1 SITE PLAN (CONCEPT)
SCALE: 1"=30'-0"

SMITH PLUMBING & HTG
1875 MAIN STREET
COLORADO SPRINGS, CO 80911
EL PASO COUNTY, COLORADO

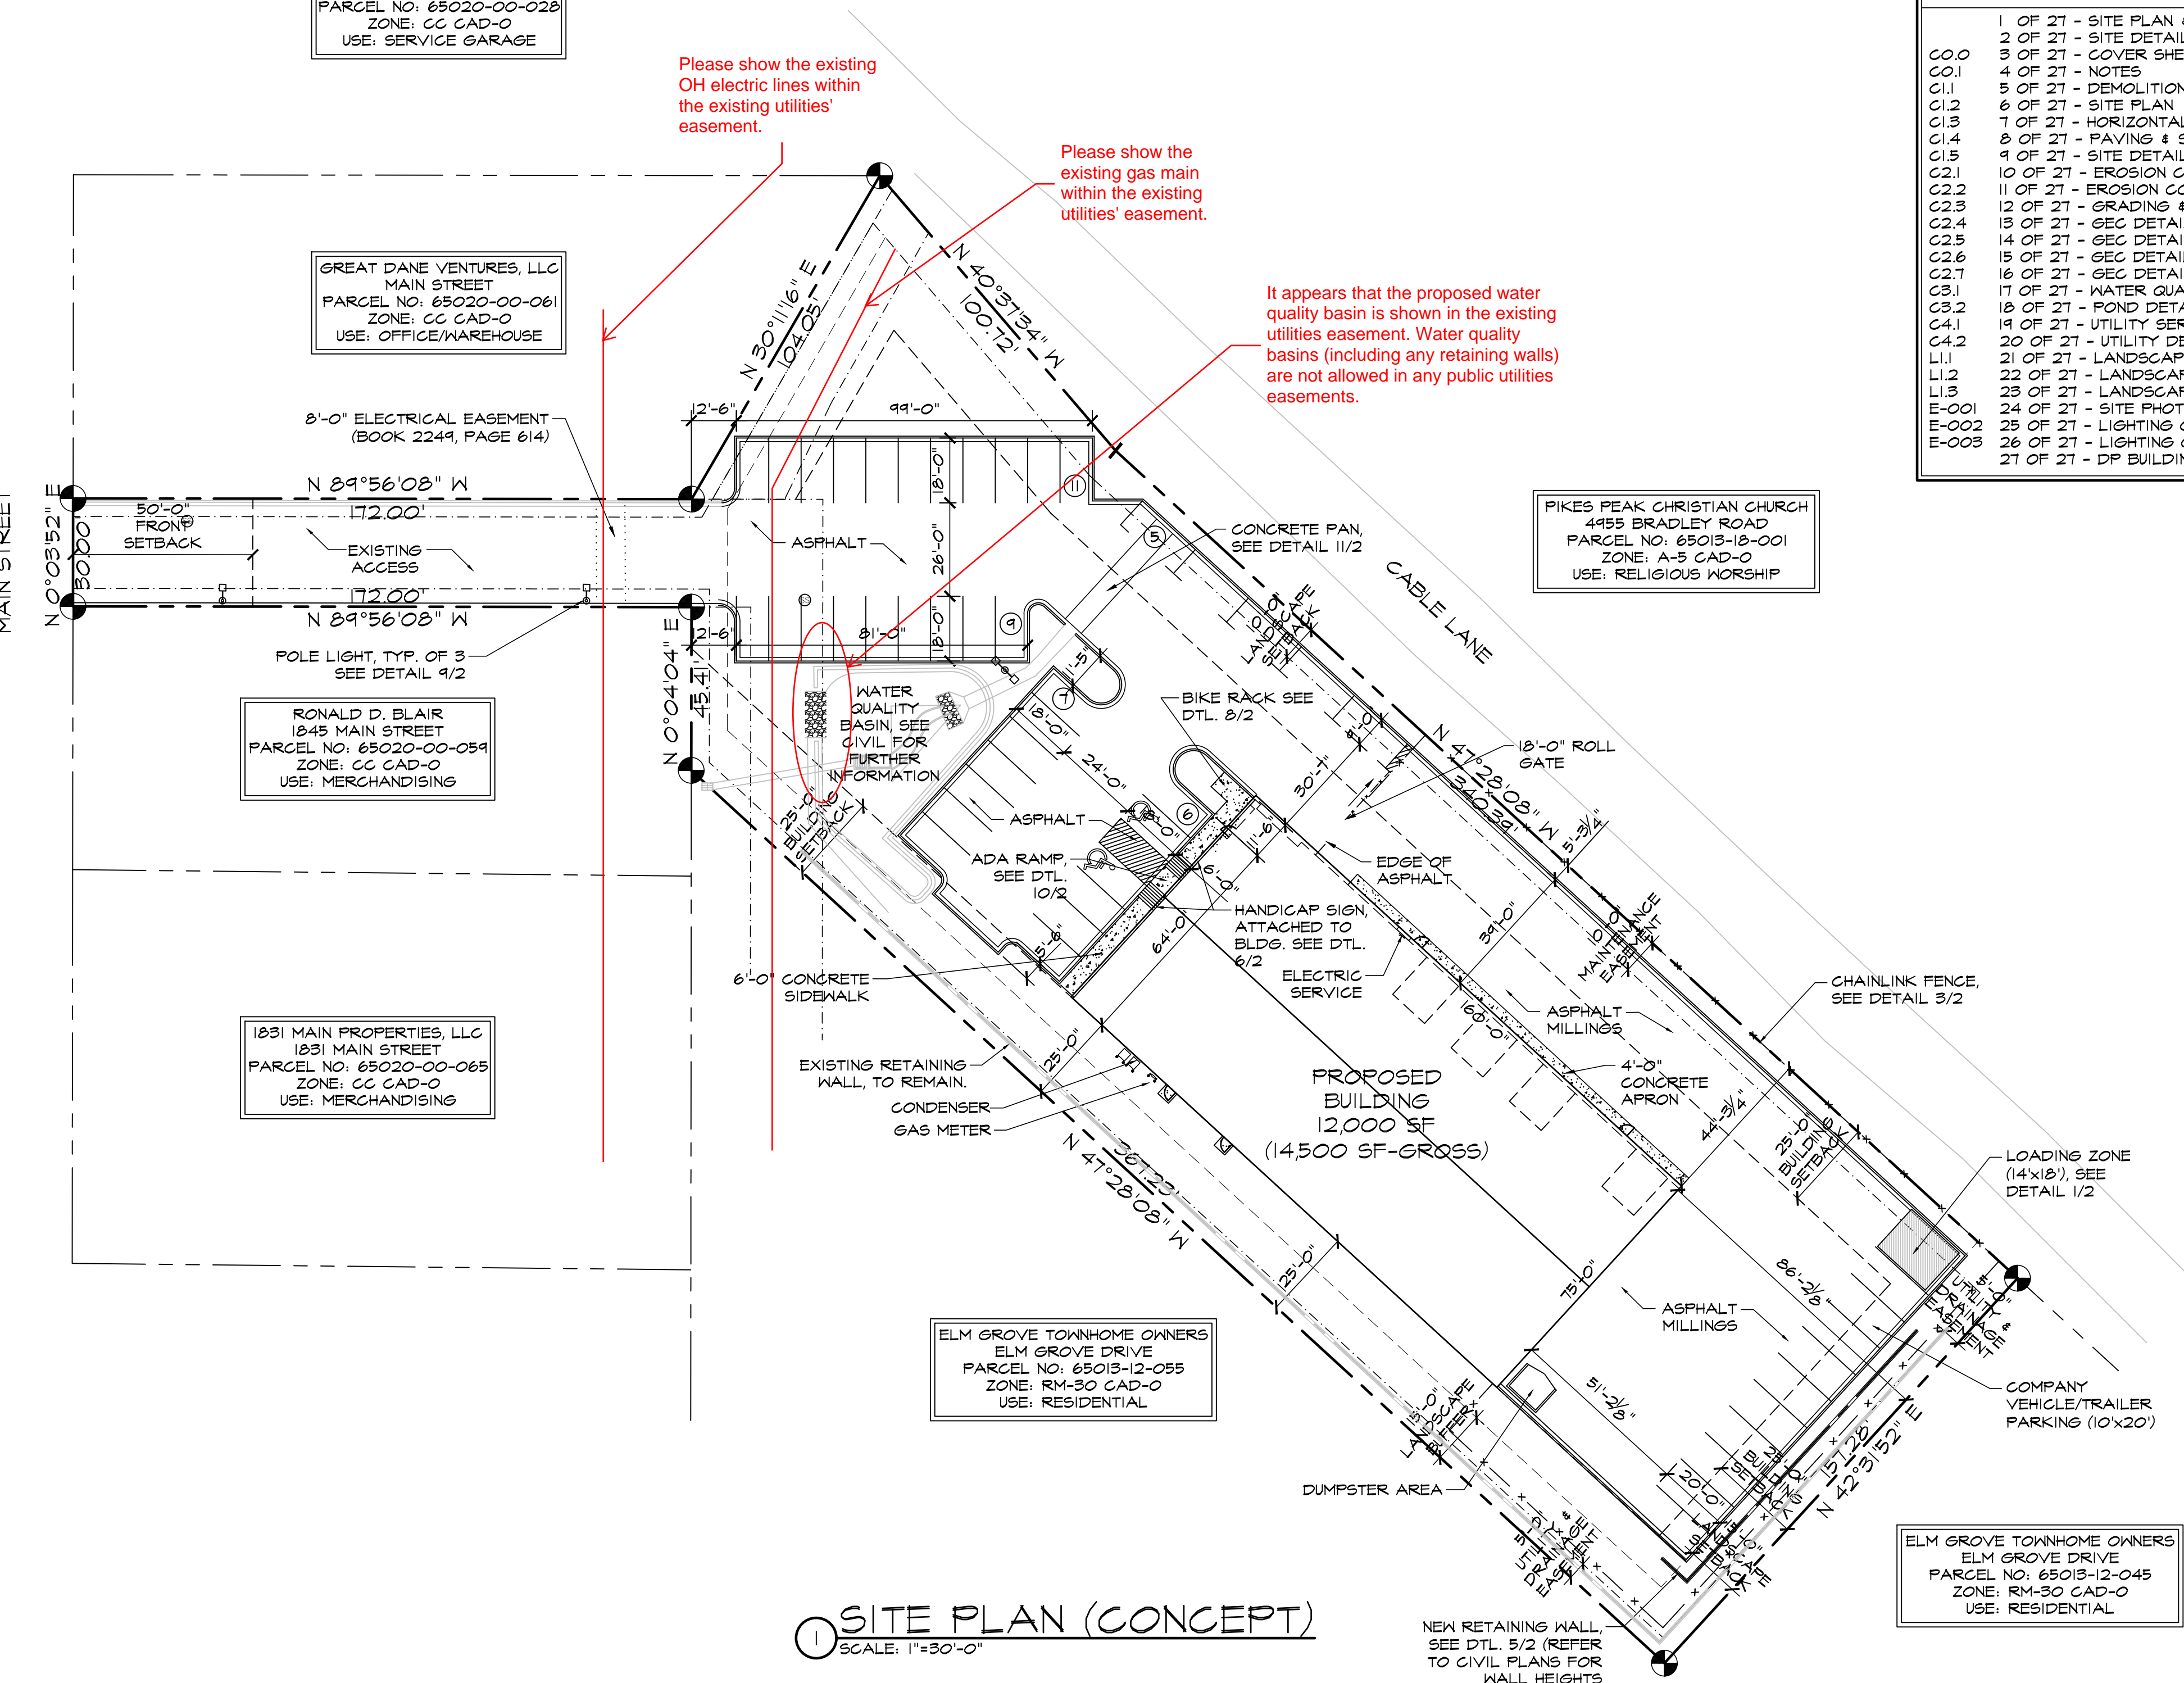
Avigation easement referenced in title commitment. Make sure this is referenced on the plan.

Include signature block for the Planning and Community Development Director a minimum of 1 inch by 2 inches

Add PCD File #
